OXFORDSHIRE COUNTY COUNCIL'S RESPONSE TO CONSULTATION ON THE FOLLOWING DEVELOPMENT PROPOSAL

Application no: 22/02866/OUT

Proposal: OUTLINE planning application for up to 120 dwellings, vehicular and pedestrian access off Ploughley Road, new pedestrian access to West Hawthorn Road, surface water drainage, foul water drainage, landscaping, public open space, biodiversity and associated infrastructure. Access off Ploughley Road is not reserved for future consideration

Location: Land East Of, Ploughley Road, Ambrosden

OVERVIEW  
SCALE 1:1000

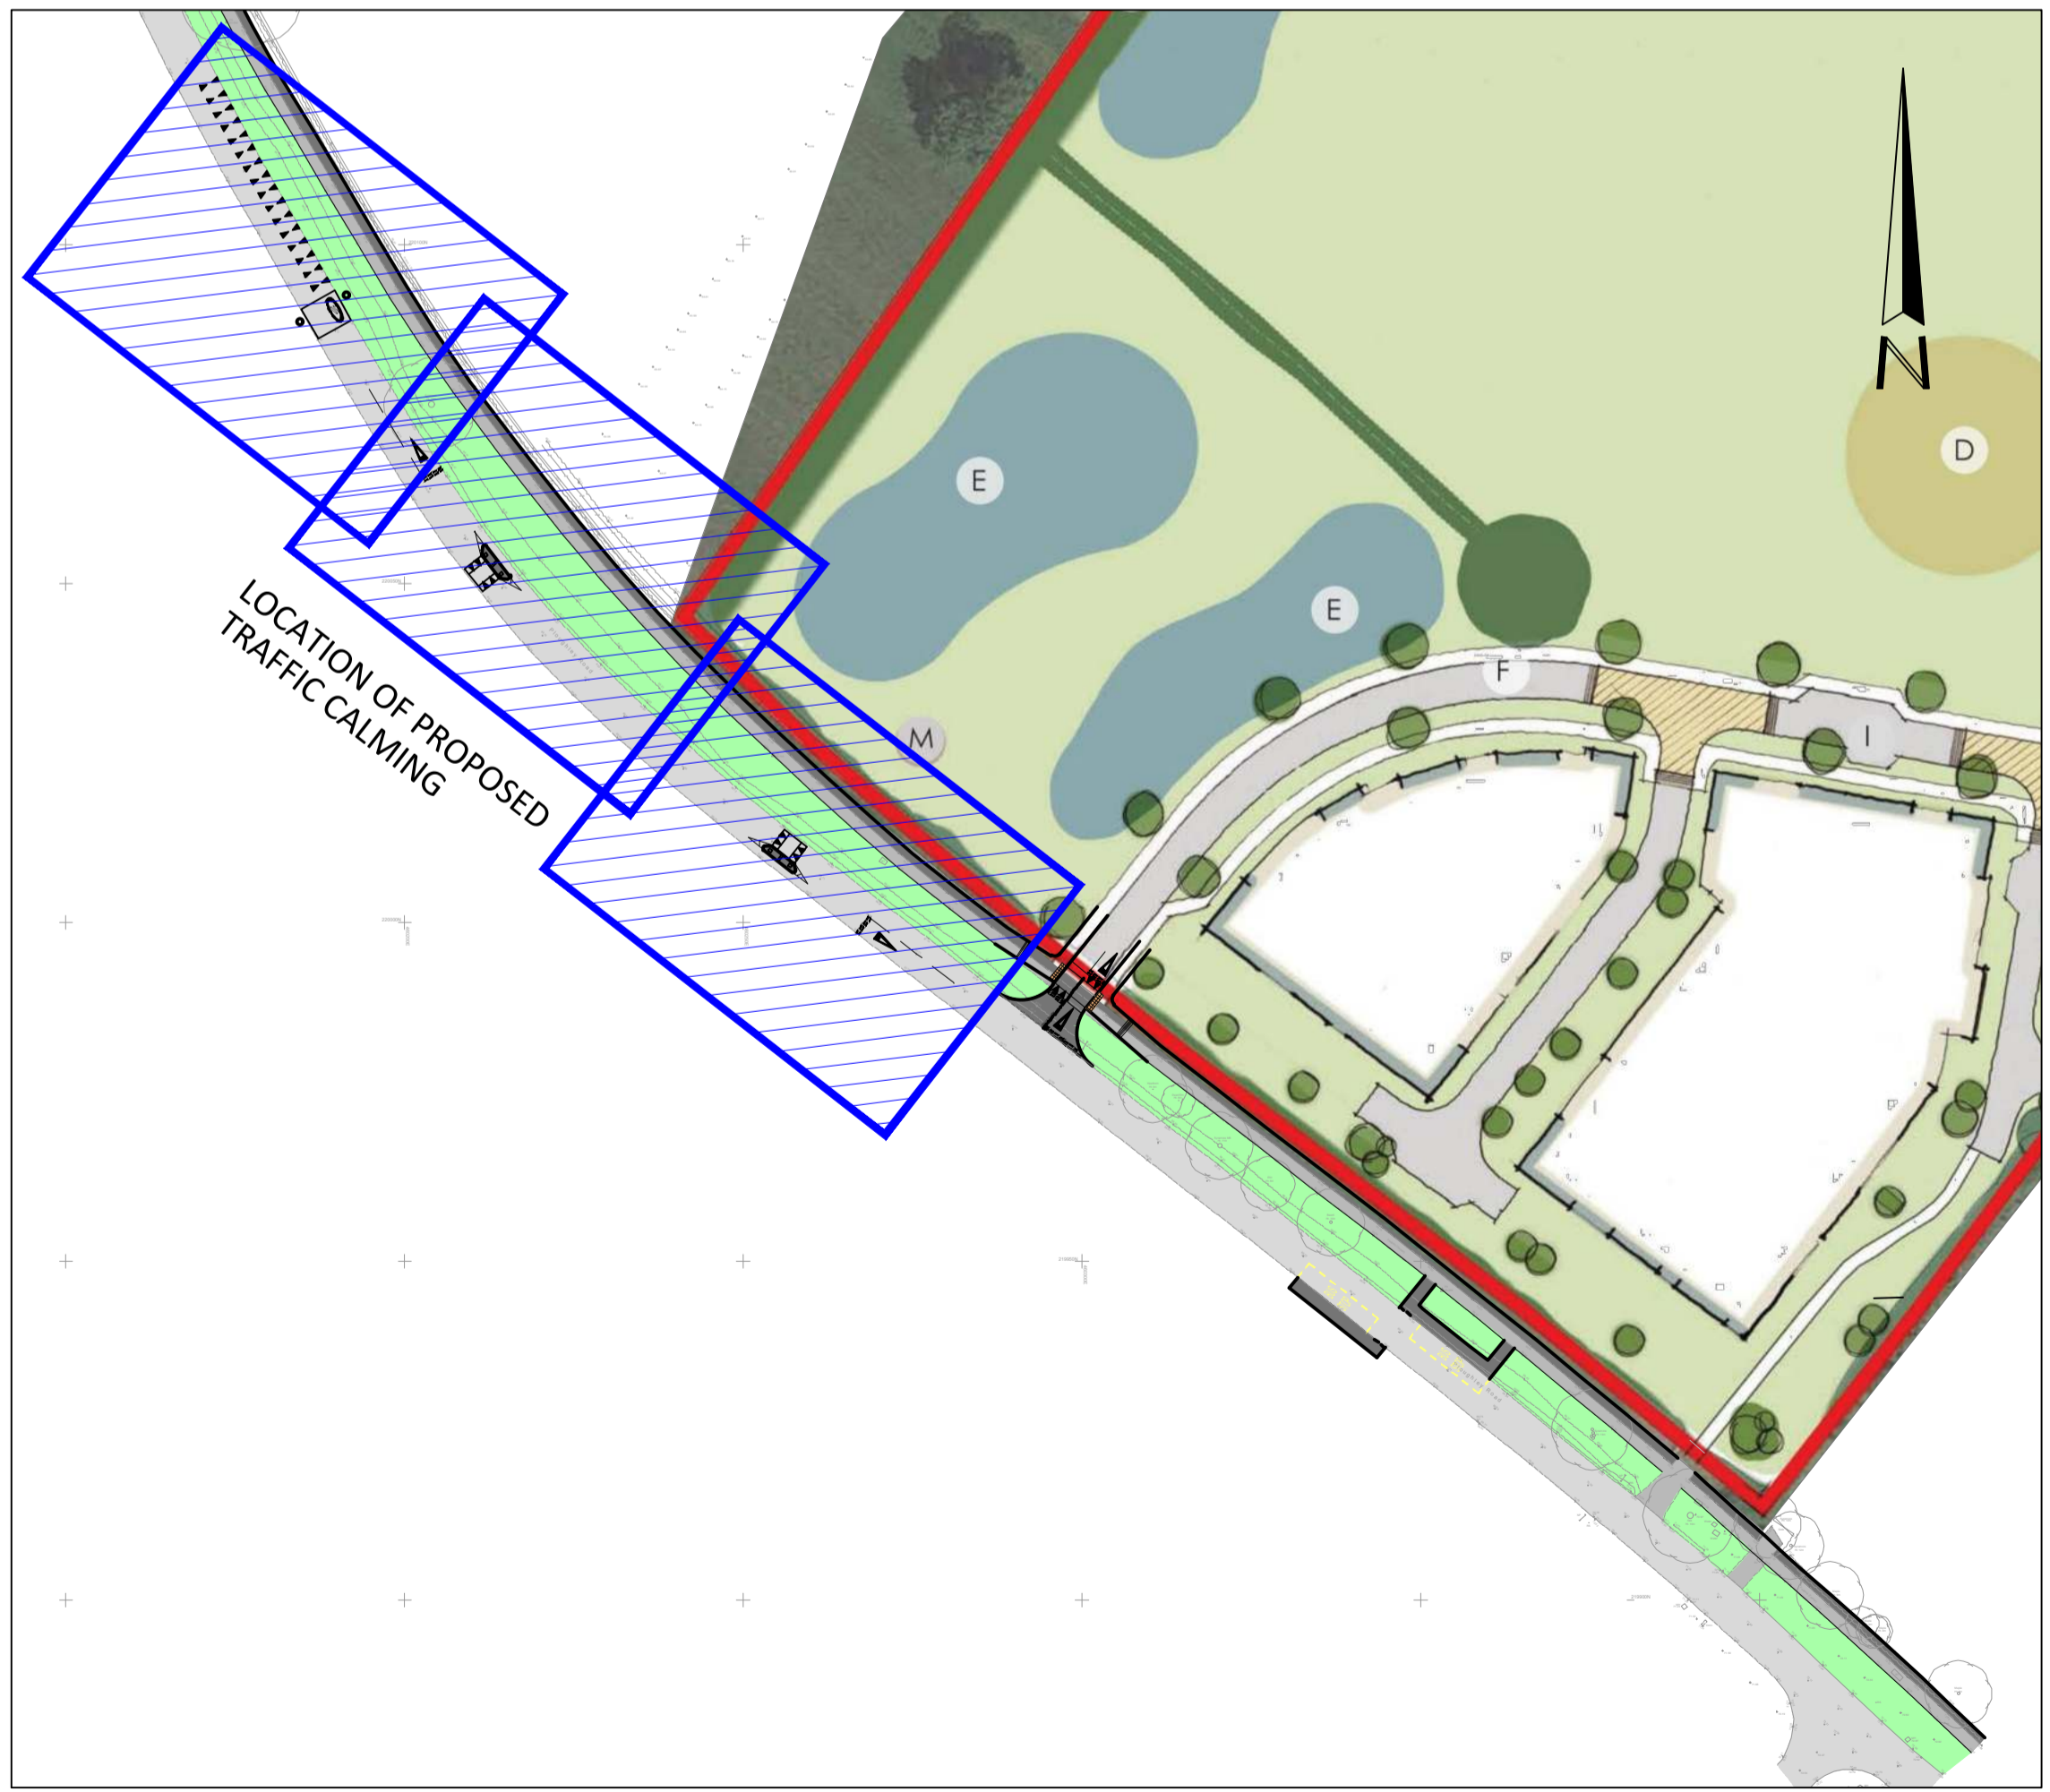
In order to reduce the approach speed of southbound vehicles, a build-out traffic calming feature has been introduced to the north of the site access. This feature replicates those on the Ploughley Road at the south entrance to the village. The effect of the build-out is three-fold:

1. Some vehicles will have to slow or stop to give way to northbound traffic
2. The full-width cushion will encourage vehicles to reduce speed
3. Southbound vehicles will be diverted to the northbound lane when passing the build-out, so will be more visible from the site access.

This calming feature will be visible to northbound traffic leaving the village and so will tend to dampen vehicle speeds towards and past the site access. The length of road up to and just past the feature will be reduced to a 30mph limit.

- Traffic-calming measures adjacent to the site access on Ploughley Road (as shown indicatively on Clarkebond drawing B05927-CLK-XX-XX-DR-C-0012 Rev. P02).

- Two bus stops on Ploughley Road. Each to comprise a two-bay shelter, Premium standard pole, flag and timetable case. The shelters are to include electrical connections for a future real time information screen (by others) (as shown indicatively on Clarkebond drawing B05927-CLK-XX-XX-DR-C-0012 Rev. P02).

- A crossing of Ploughley Road to the northbound bus stop (as shown indicatively on Clarkebond drawing B05927-CLK-XX-XX-DR-C-0012 Rev. P02).
- Improvements to the bridleway between the site and West Hawthorn Road (as shown indicatively on Clarkebond drawing B05927-CLK-XX-XX-SK-C-0001 Rev. P01). This may be on a separate short-form S278.
